Building Code of Australia 2010 Assessment Report

6-16 Atchison Street, St Leonards NSW

Prepared for: Francis-Jones Morehen Thorp Architecture
Level 5
140 George Street
SYDNEY NSW 2000

Date: 2nd July 2010

**Basement Loading Dock B1**

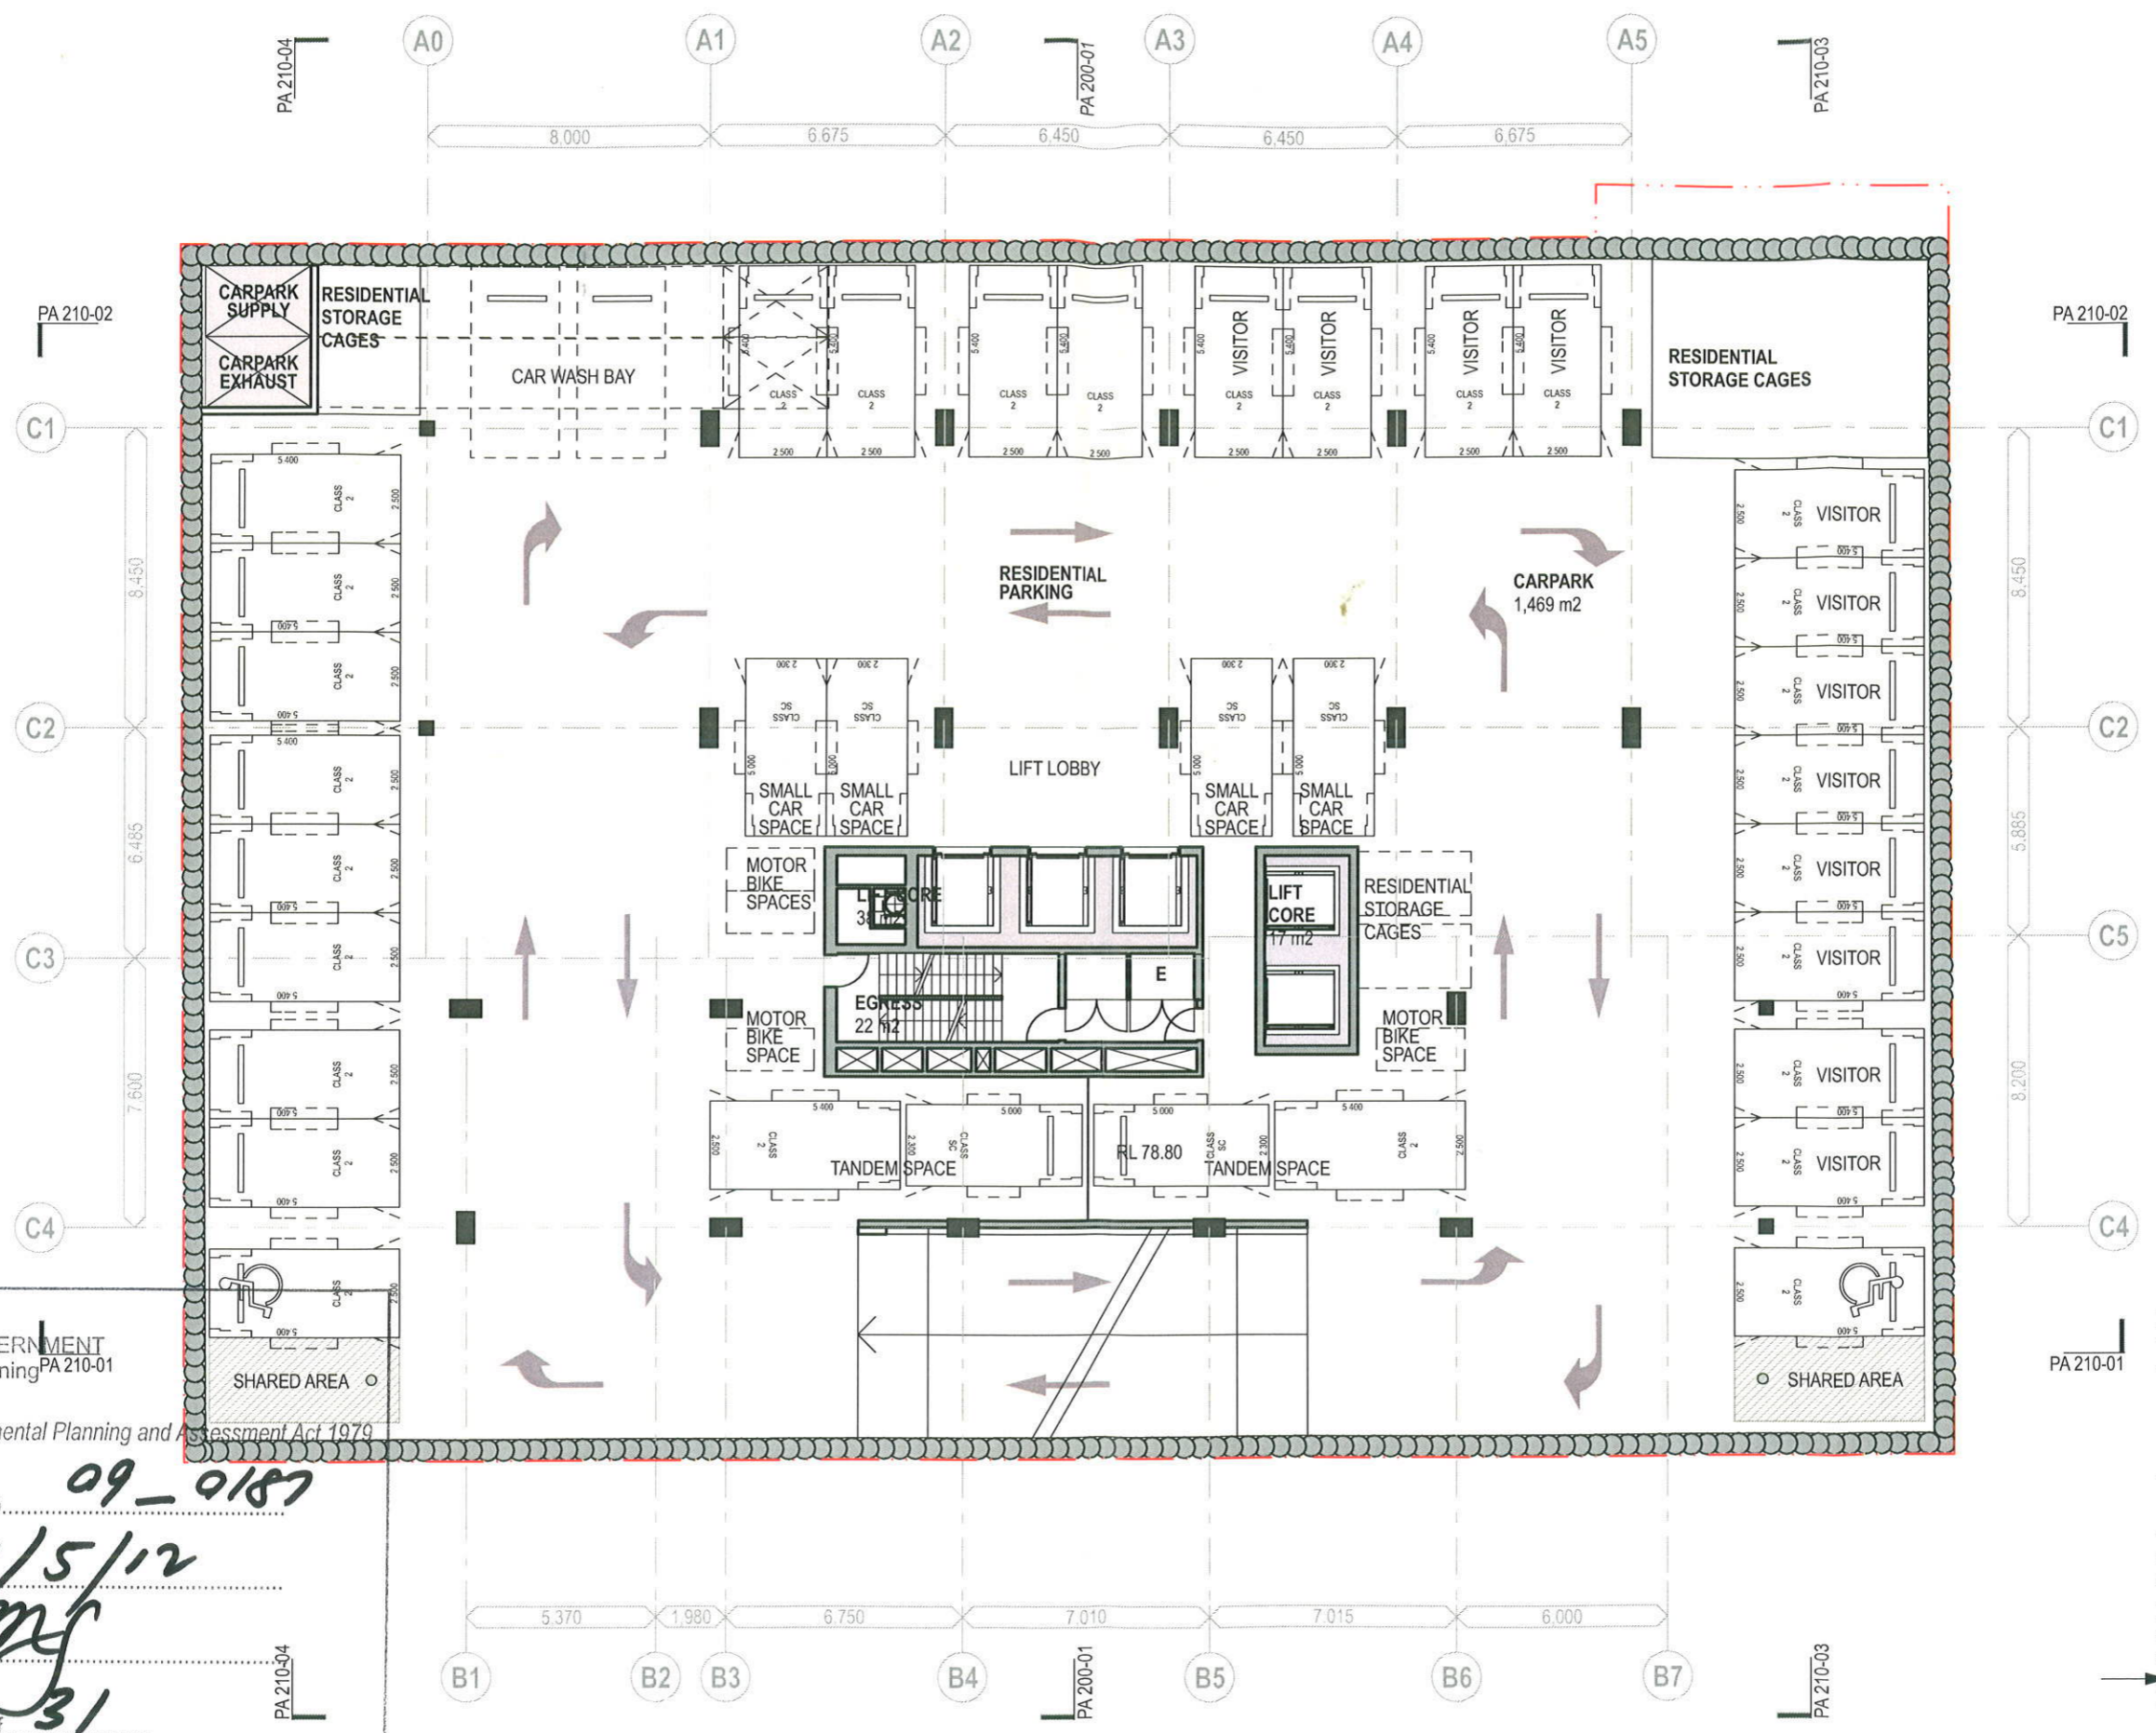
We note compliant egress distances to the Basement carpark levels, however plans are required to be detailed to show alternative exits to the Basement Level 1 loading dock/hotel parking and Mezzanine Level to the plant and storage areas for compliant egress distances.

We note the use of required non fire-isolated stairs forming part of an egress path to the Basement Mezzanine and loading lock levels. These stairs are required to be within 20m of the fire-isolated stair, further details are required.

Note comments regarding the electrical riser doors located within the fire stair to Basement levels, required to be re-designed.

04 PLAN Penthouse Type 1 L30-31
1:500

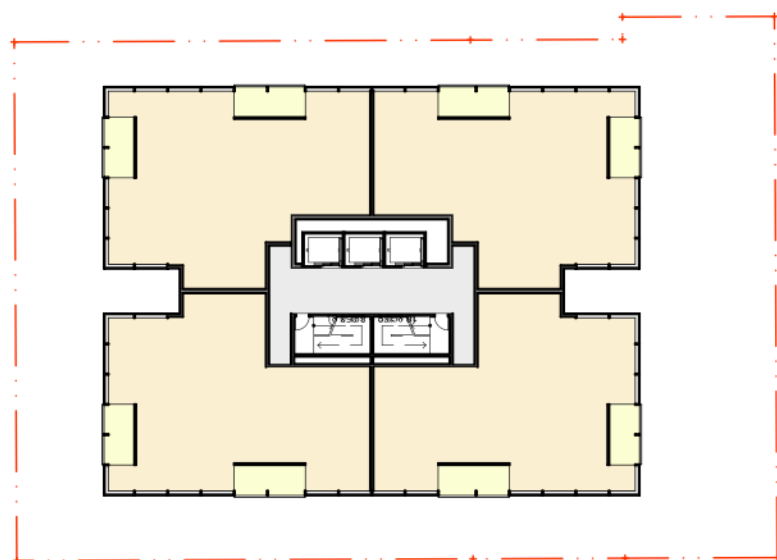
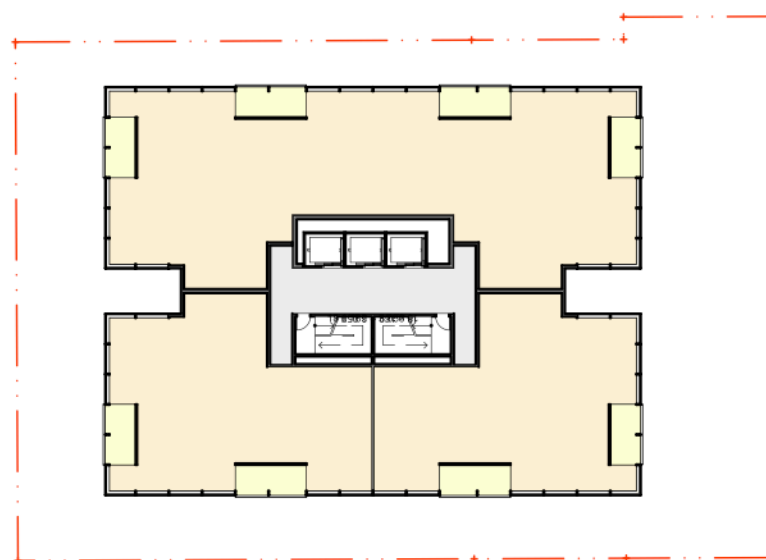
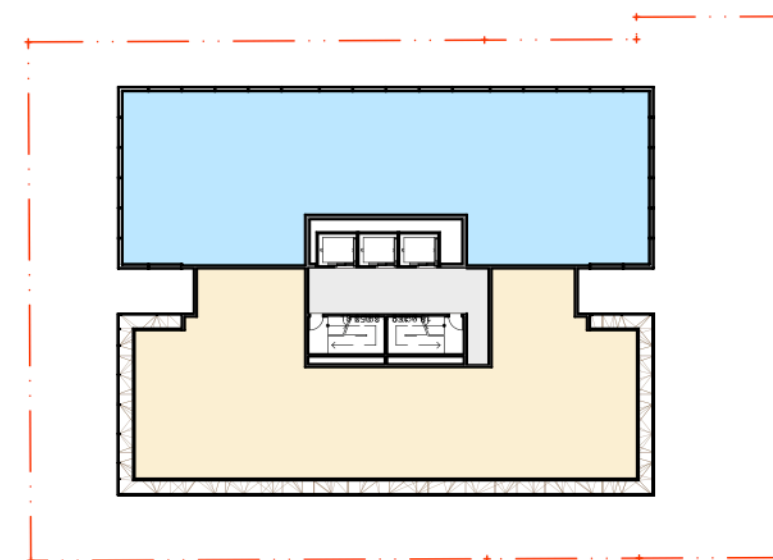
- Basement Level 1 – Loading dock/hotel parking
- Basement Mezzanine level – Plant and storage areas
- Ground Floor Lower – Residential lobby/café area
- Ground Floor Upper – Hotel lobby
- Level 1 – Gym/pool area
- Penthouse Levels (Residential) – detail that 2 exits are provided.
